<b>Report title:</b>	Stage 1 RSA Designers Response – Proposed Lidl Foodstore, Blackmoorfoot Road.
<b>Date:</b>	22 <sup>nd</sup> May 2024
<b>Document reference and revision:</b>	21-209-008.01
<b>Prepared by:</b>	Nick Calder
<b>On behalf of:</b>	Bryan G Hall

<b>Project:</b>	Priority T Junction, proposed Lidl foodstore on land of Crosland Moor, Huddersfield
<b>Report title:</b>	Stage 1 RSA Designers Response
<b>Prepared by:</b>	
<b>Name:</b>	Nick Calder
<b>Position:</b>	Principal Engineer
<b>Signed:</b>	
<b>Organisation:</b>	Bryan G Hall
<b>Date:</b>	22 <sup>nd</sup> May 2024
<b>Approved by:</b>	
<b>Name:</b>	Stuart Wilkins
<b>Position:</b>	Director
<b>Signed:</b>	
<b>Organisation:</b>	Bryan G Hall
<b>Date:</b>	22 <sup>nd</sup> May 2024

date August 2023  
status Planning  
scale 1:500 @ A3  
drawn KA checked BM  
job no. 2783 dwg no. P413 rev. D

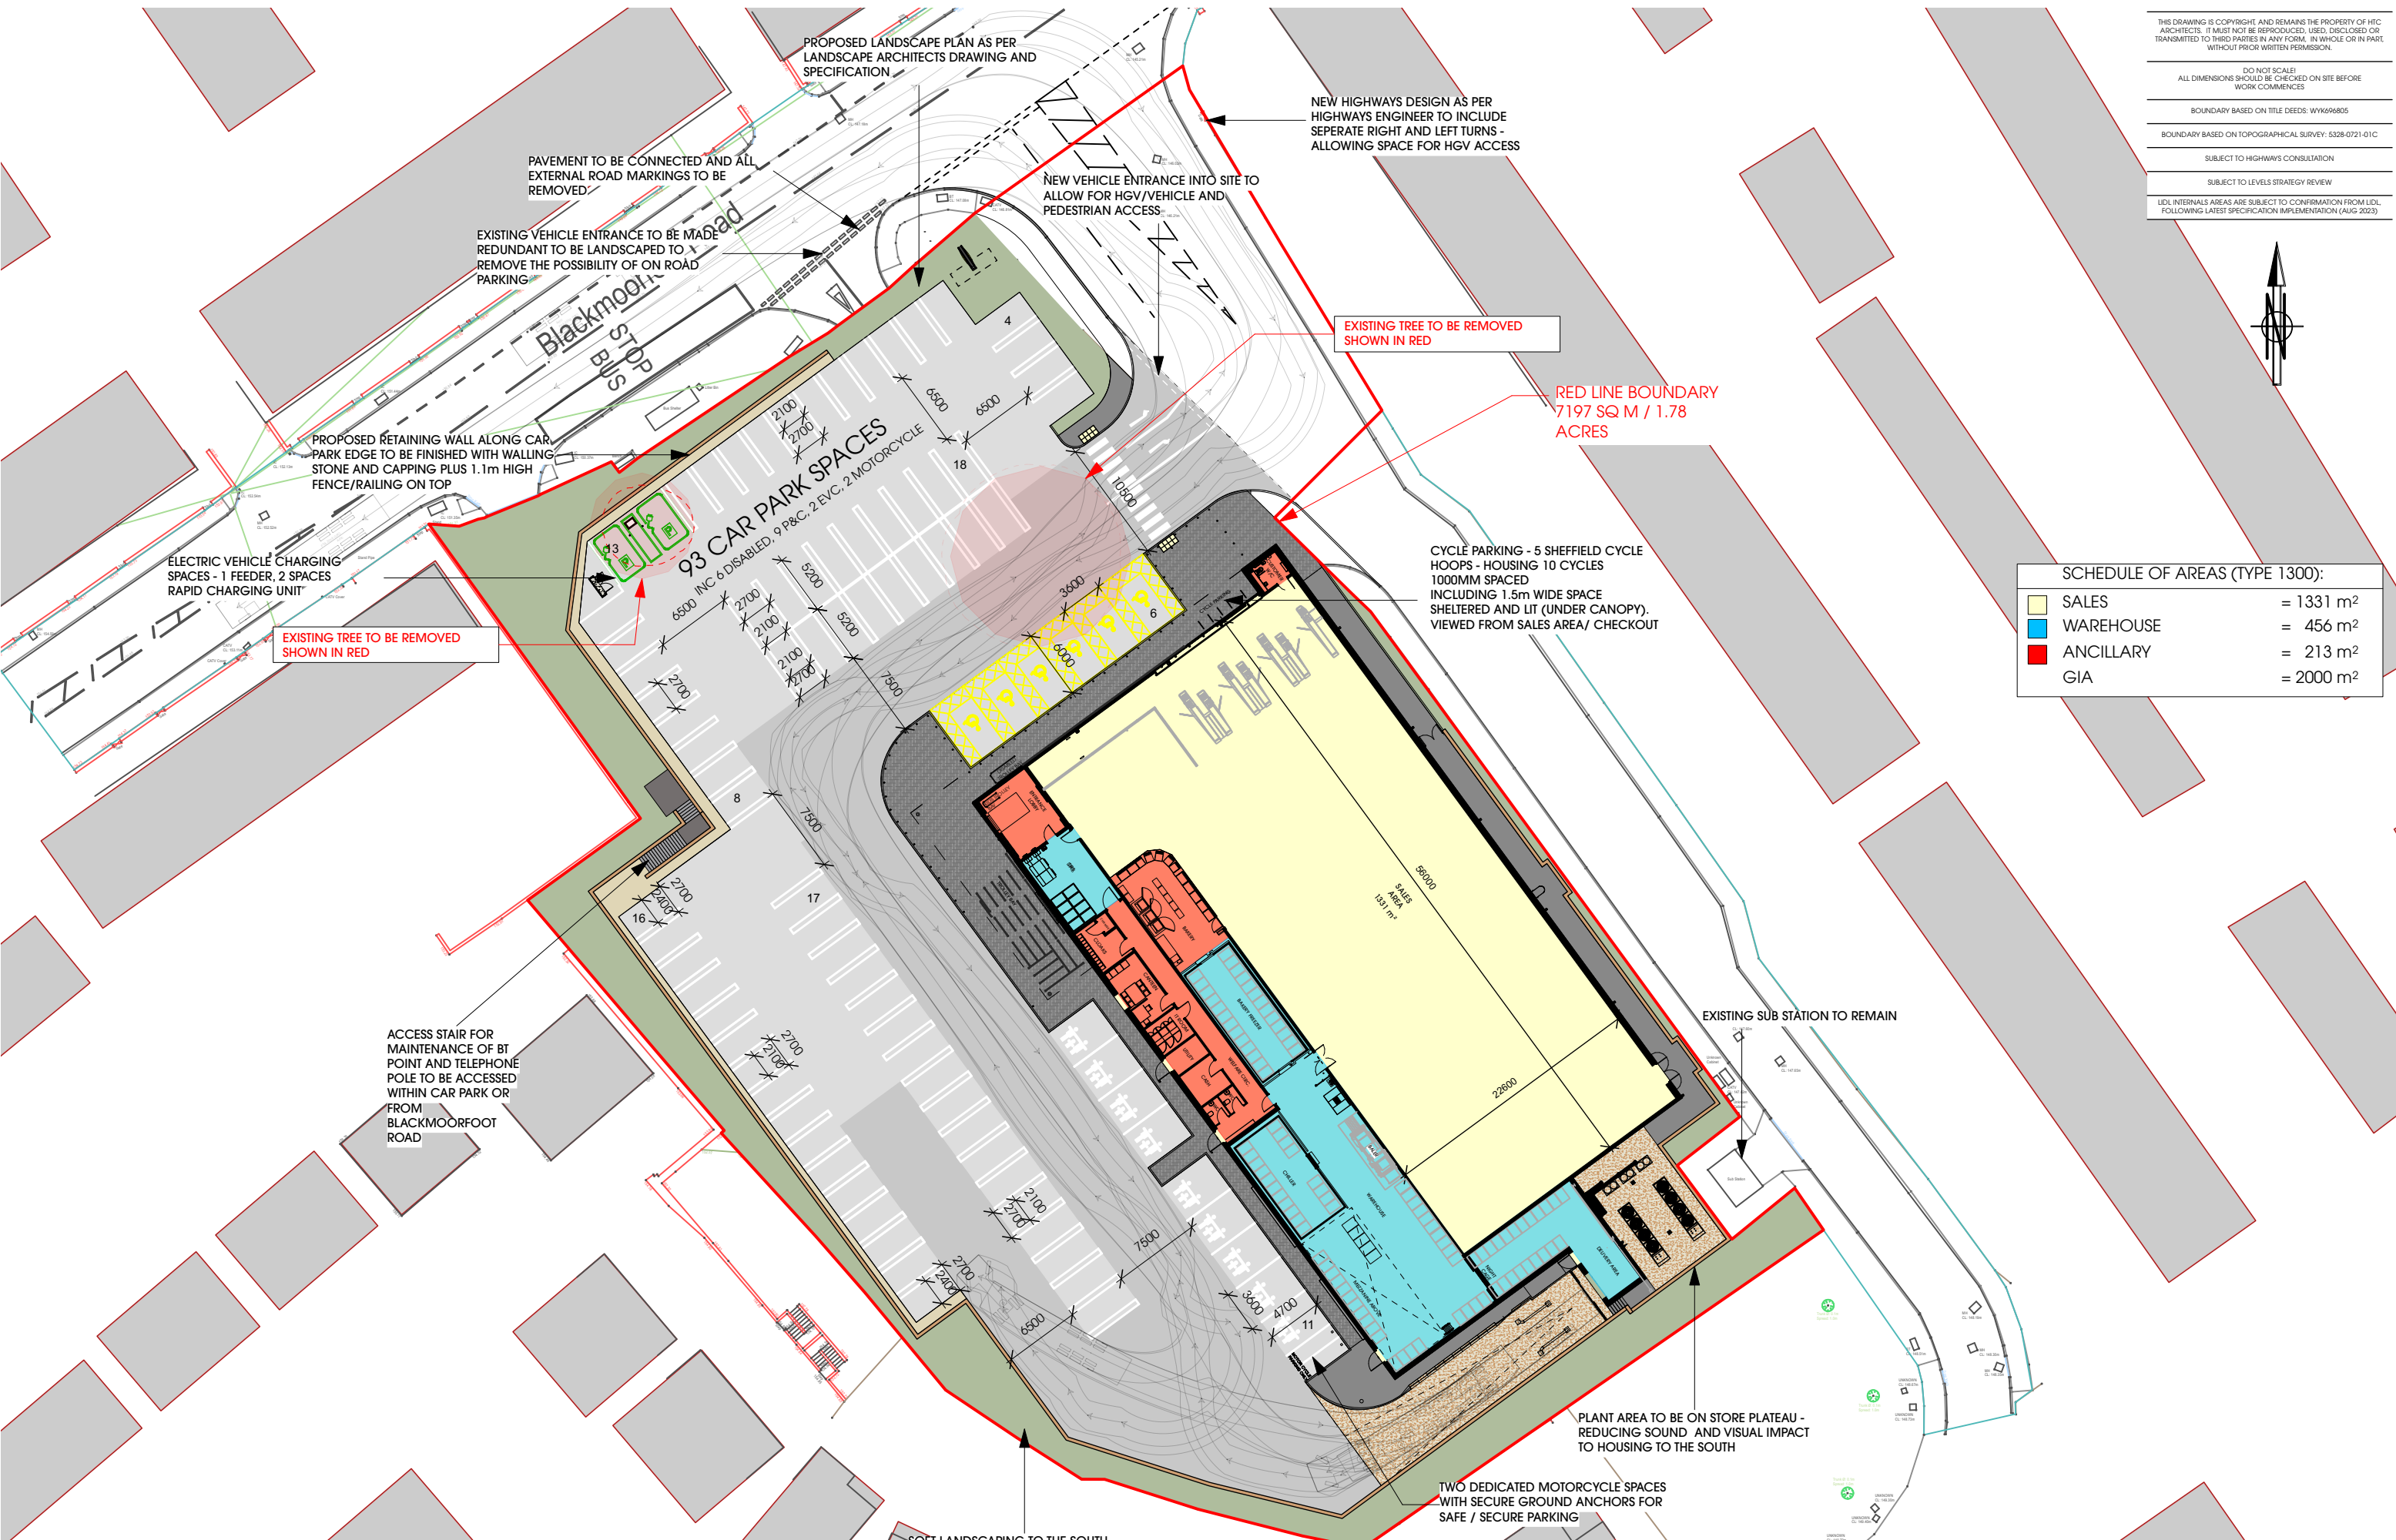
RSA problem	RSA recommendation	Design organisation response	Overseeing Organisation response	Agreed RSA action
2.1 – A lack of suitable crossing facilities will increase both the risk of trips and falls as well as pedestrian/vehicle collisions.	It is recommended that an uncontrolled crossing with tactile paving is provided over the site access junction on the pedestrian desire line.	BGH accepts this recommendation and will provide a uncontrolled pedestrian crossing with tactile paving crossing over the proposed site junction. This will be picked up at detailed design stage.	<b>For KC to complete</b>	<b>TBC</b>
